**Subject:** Vickery Extension Project Response to Submissions

Thank you for your request on 3 September 2019 via the Planning Portal inviting the Biodiversity and Conservation Division (BCD) to provide advice on the Response to Submissions (RTS) report for the Vickery Extension Project.

Figure 2-3

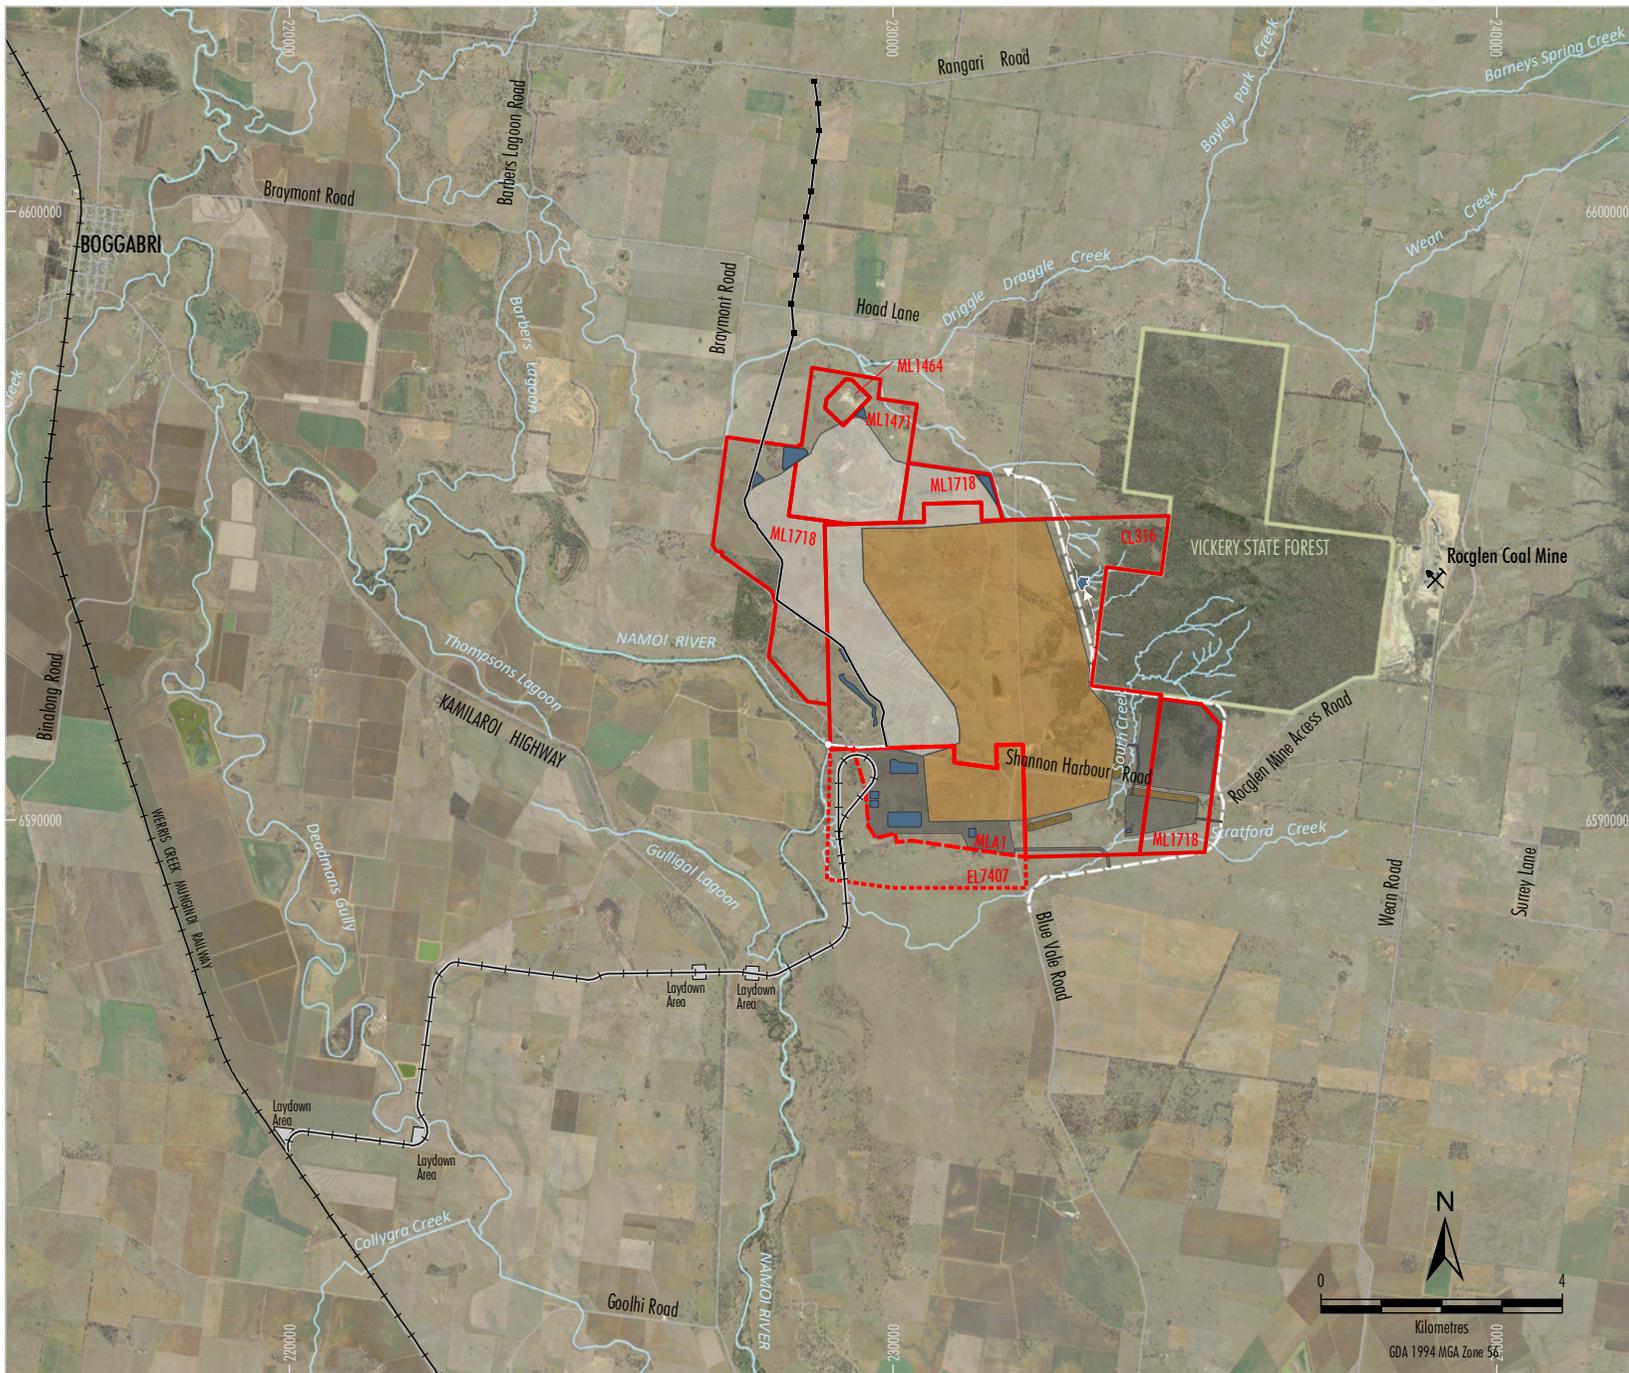
To date, modelling work has been based on conceptual design dimensions. BCD acknowledges that the proponent has agreed to provide the final detailed rail spur design for our review, however we would like to reiterate Recommendation 1 from our response to the EIS.

5. BCD requests the opportunity to review the final design to ensure design objectives have been met.
